El Paso County Planning and Community Development

Re: Falcon Marketplace Preliminary Plan (SP-17-001) Response 6

Please accept this response letter to your review 4 comments dated August 27, 2018.

LANDSCAPE PLAN - AREA 'E'

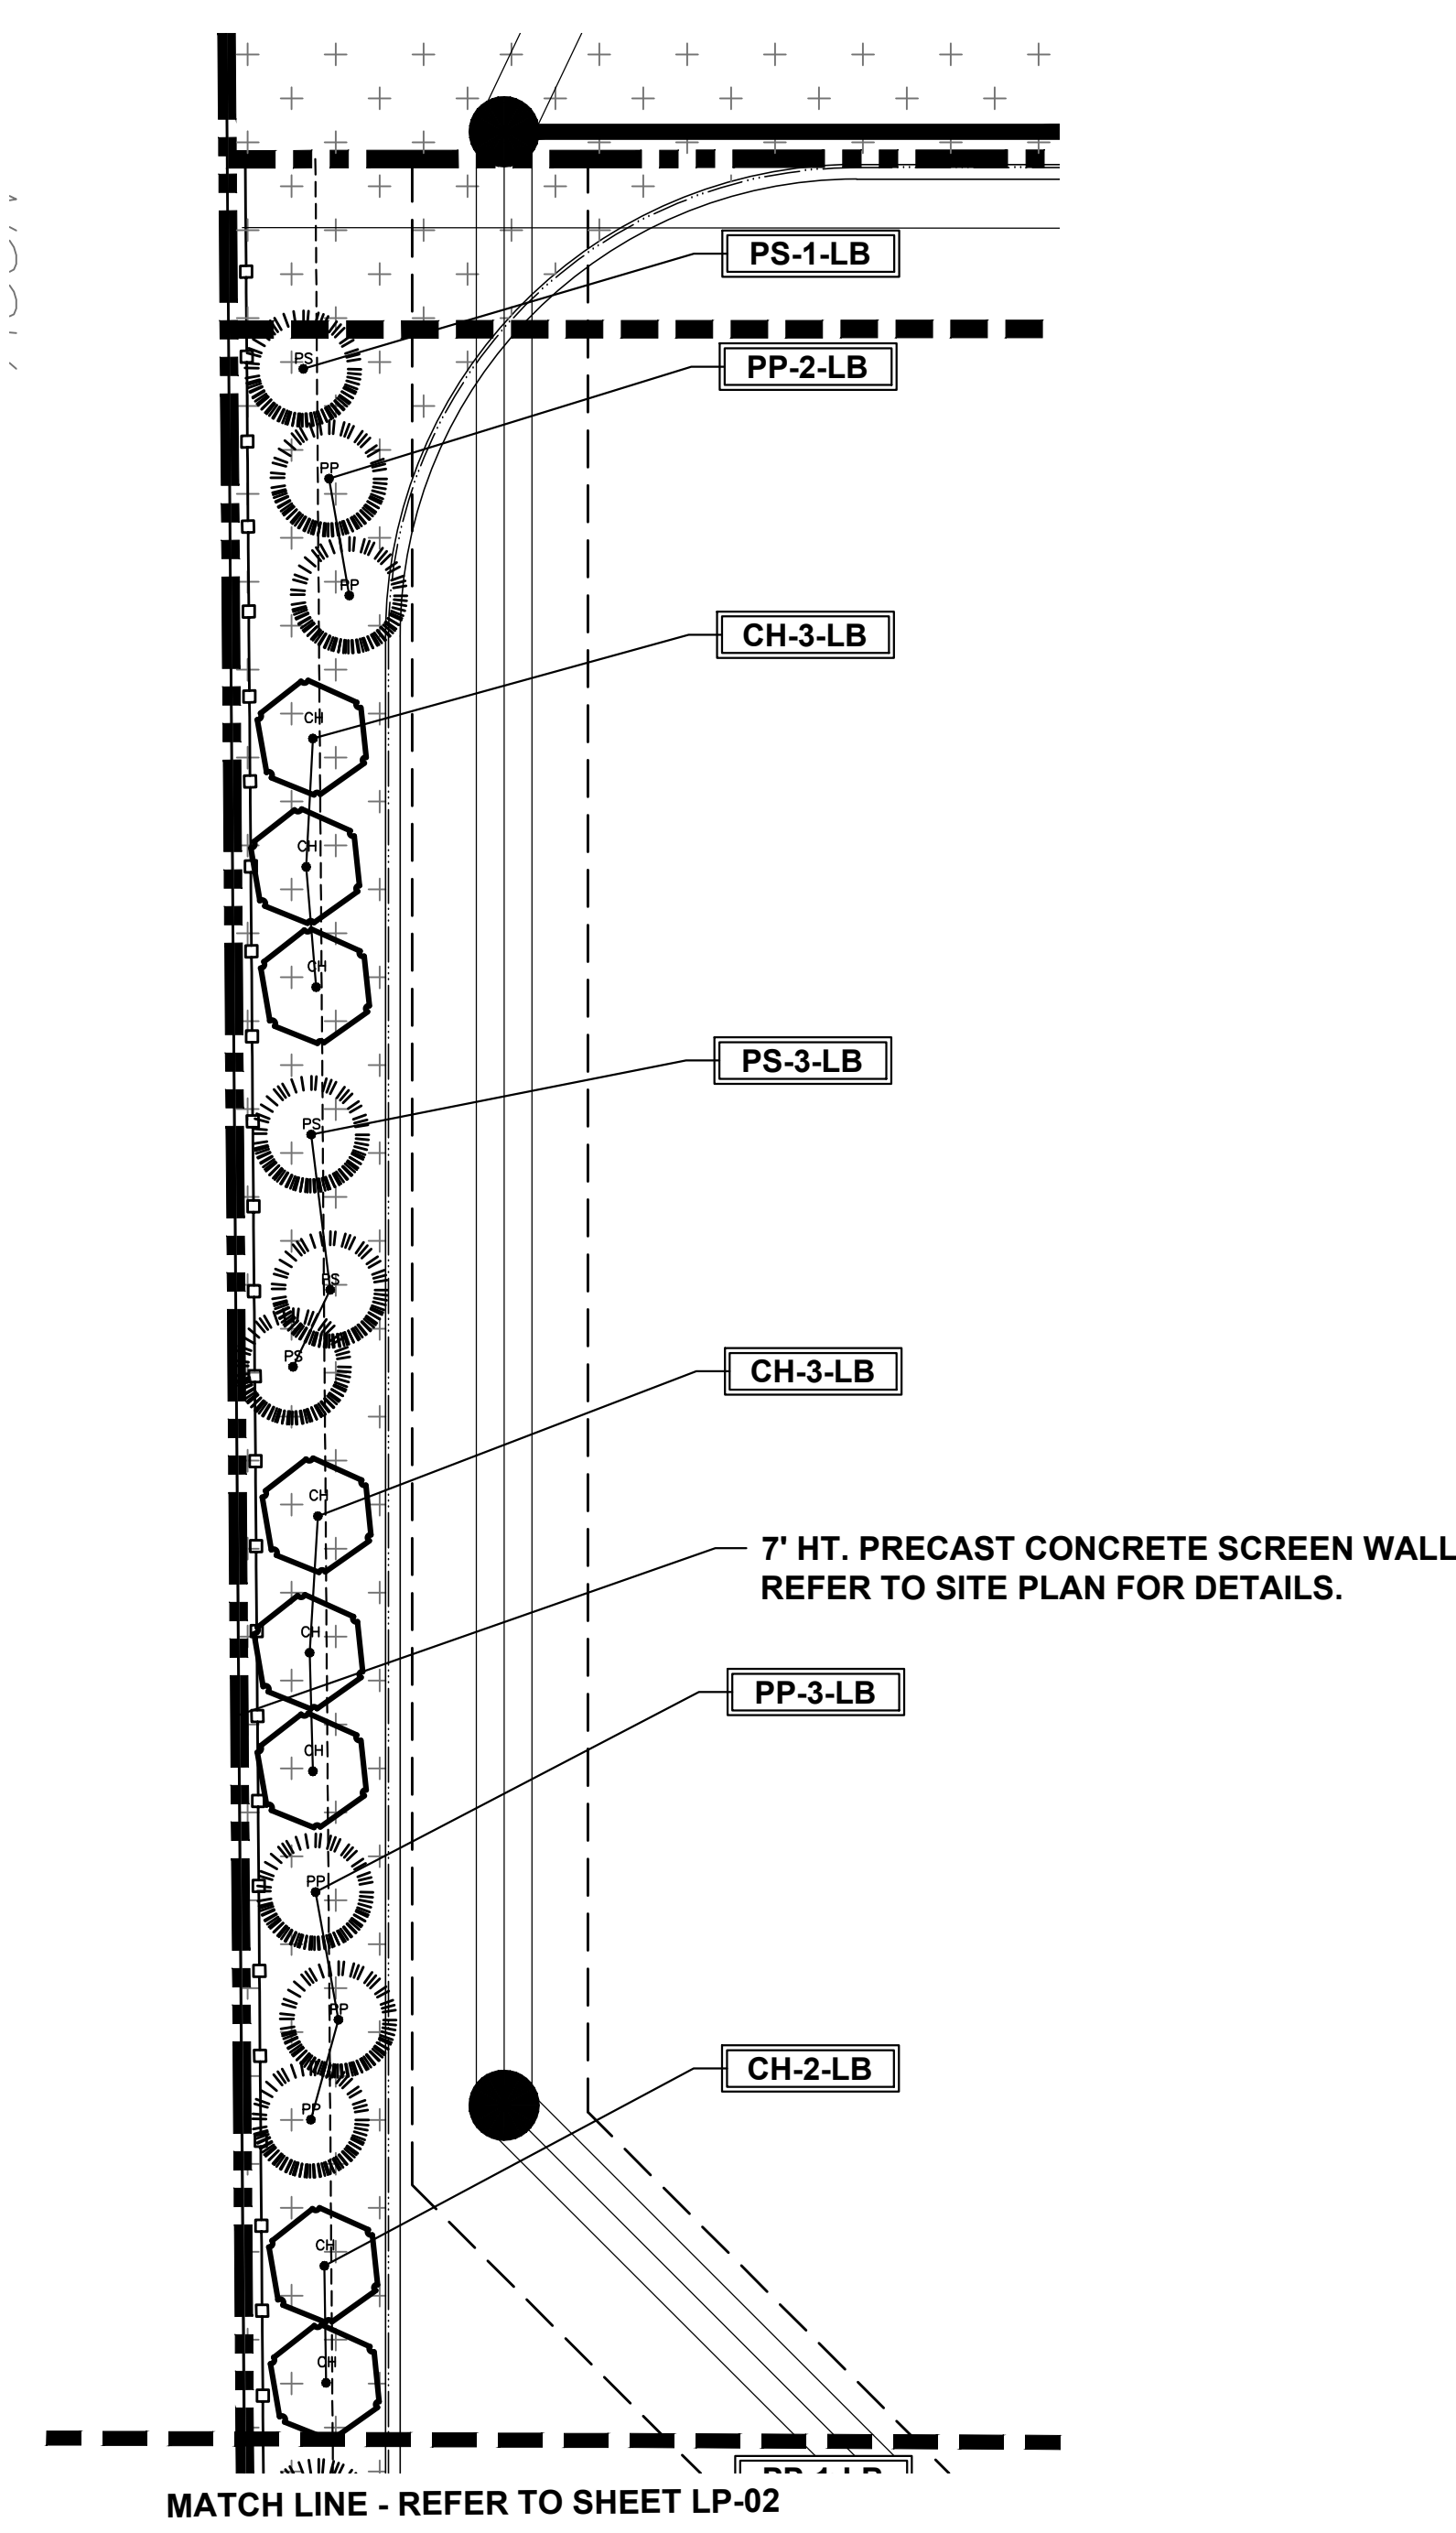
13. The landscape plan included with this submittal shows trees in existing and proposed ROW in several areas including along Meridian Road. Some of these trees need to be moved depending on final site design and construction plans. A license agreement will be required at the final plat stage for private landscaping remaining in the ROW, including the proposed roundabouts. Comment remains. **Comment remains.**
Landscape plan adjusted after conversation review with Staff.

**C7.2**

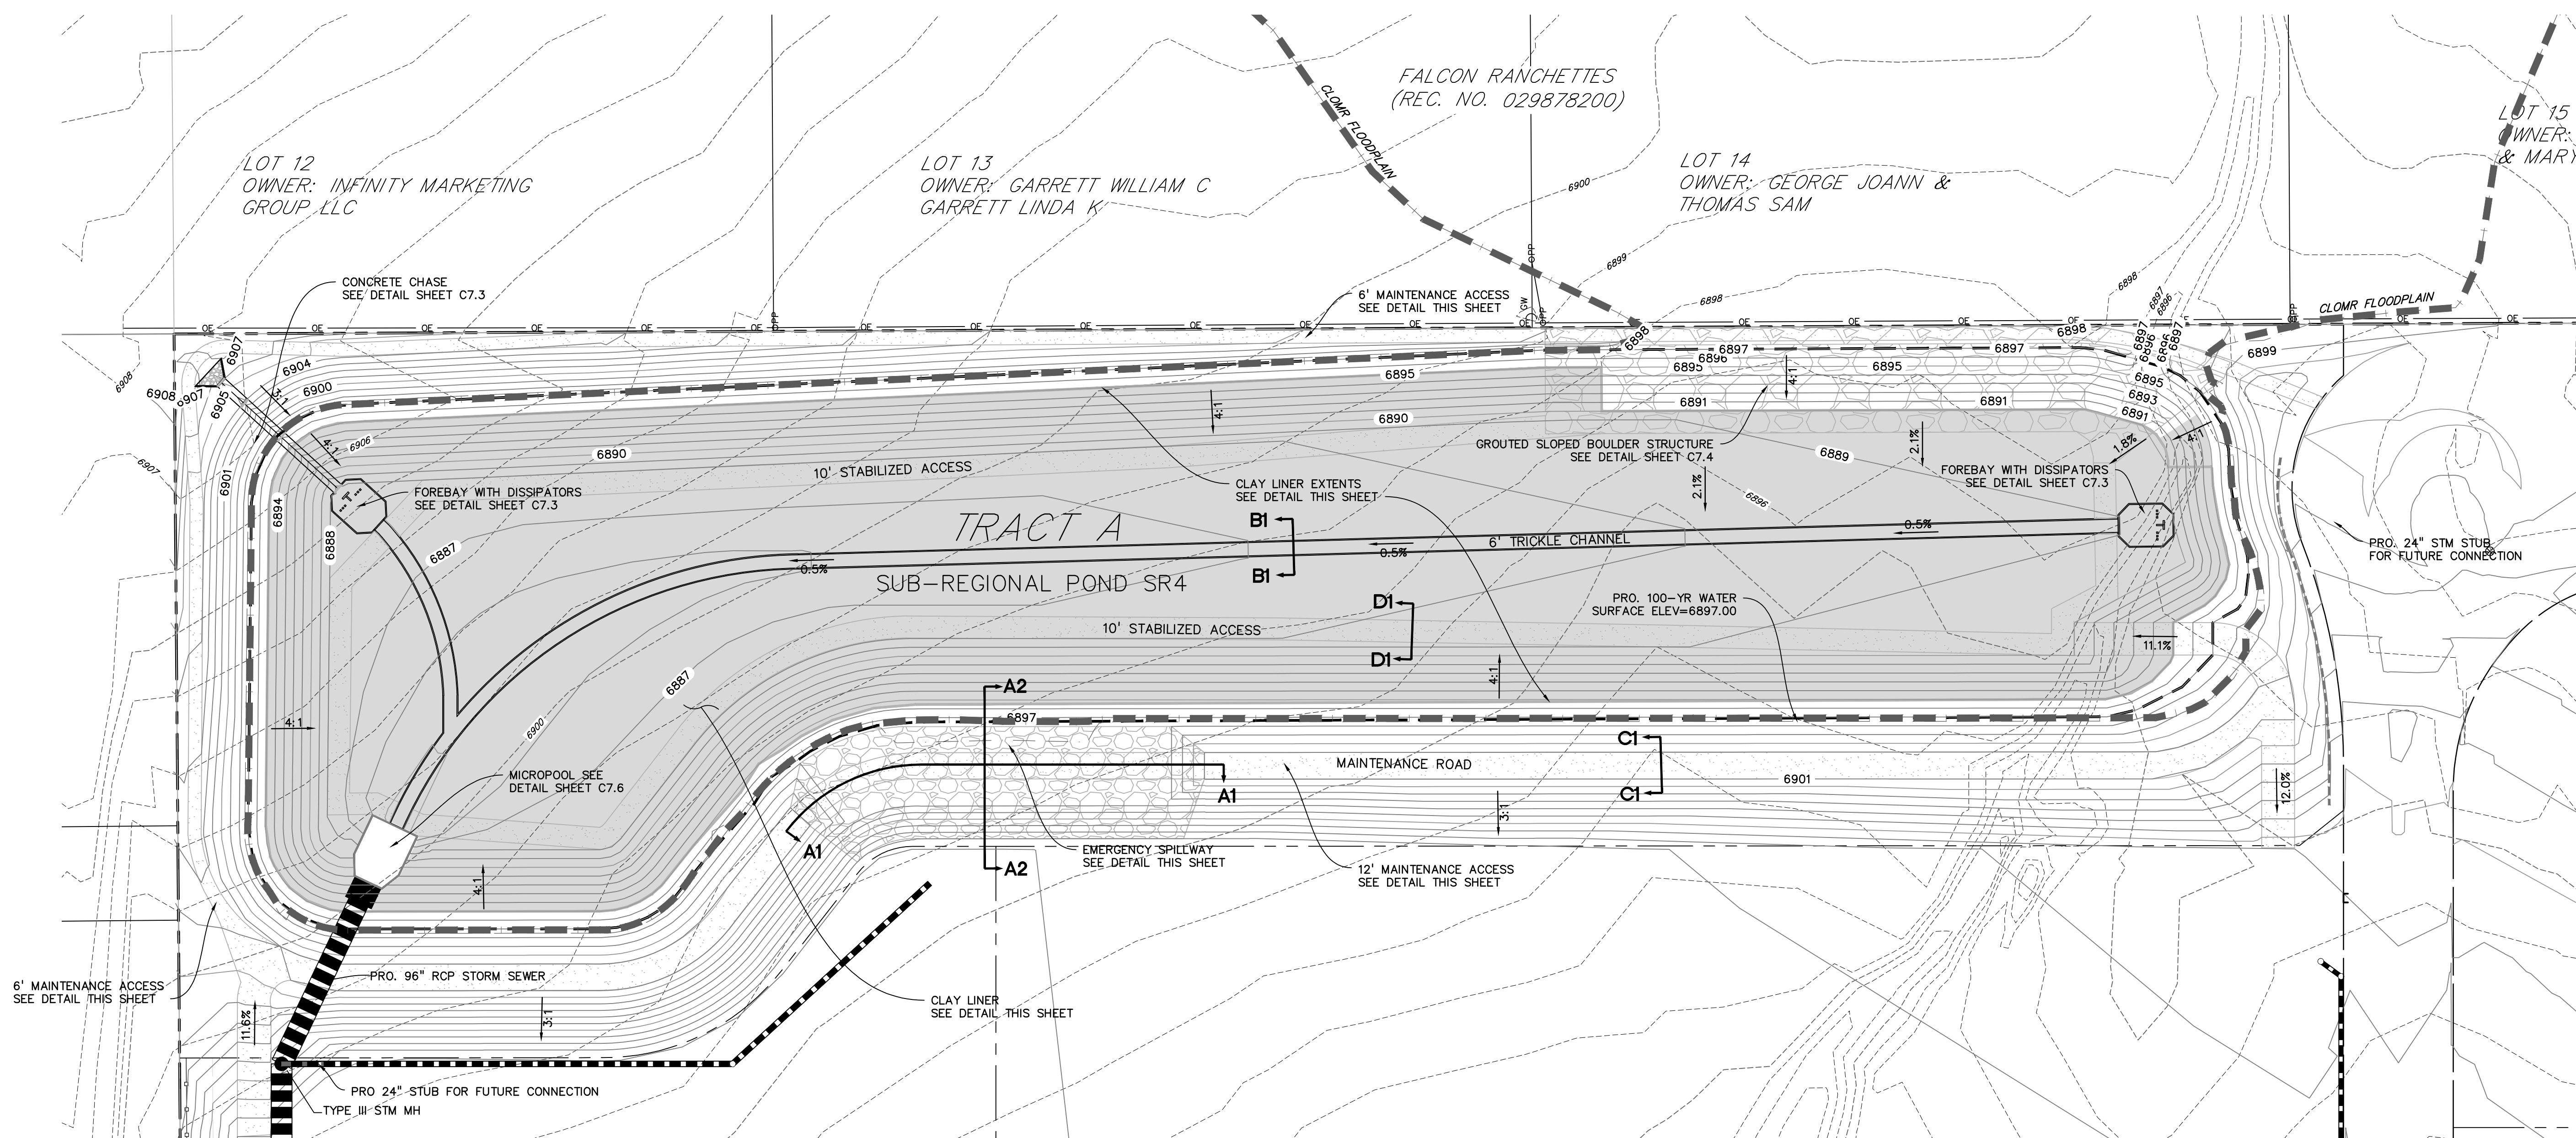
- c. Consider replacing the proposed area drain and pipe at the northwest corner with a swale along the north property line to the proposed rundown. Maintenance access appears likely to be difficult as proposed and the geotech. study recommends “properly designed drainage swale” at the tops of excavation slopes. Partially resolved; stabilization of and maintenance access to the 3:1 (and steeper?) excavated slope along the north side of Pond SR4 will need to be further addressed with the final pond design. *(If the extent of overlot grading includes the slopes, this needs to be addressed with overlot grading.) Comment remains; access road design, offsite grading (requiring easements) sheet flow locations and rundowns and the concrete rundown need additional detail to ensure adequate access and functioning.* Unresolved. **Partially resolved; see remaining redlines. Swale has been revised to a pipe drain with riprap apron upstream. Design details have been coordinated with staff.**
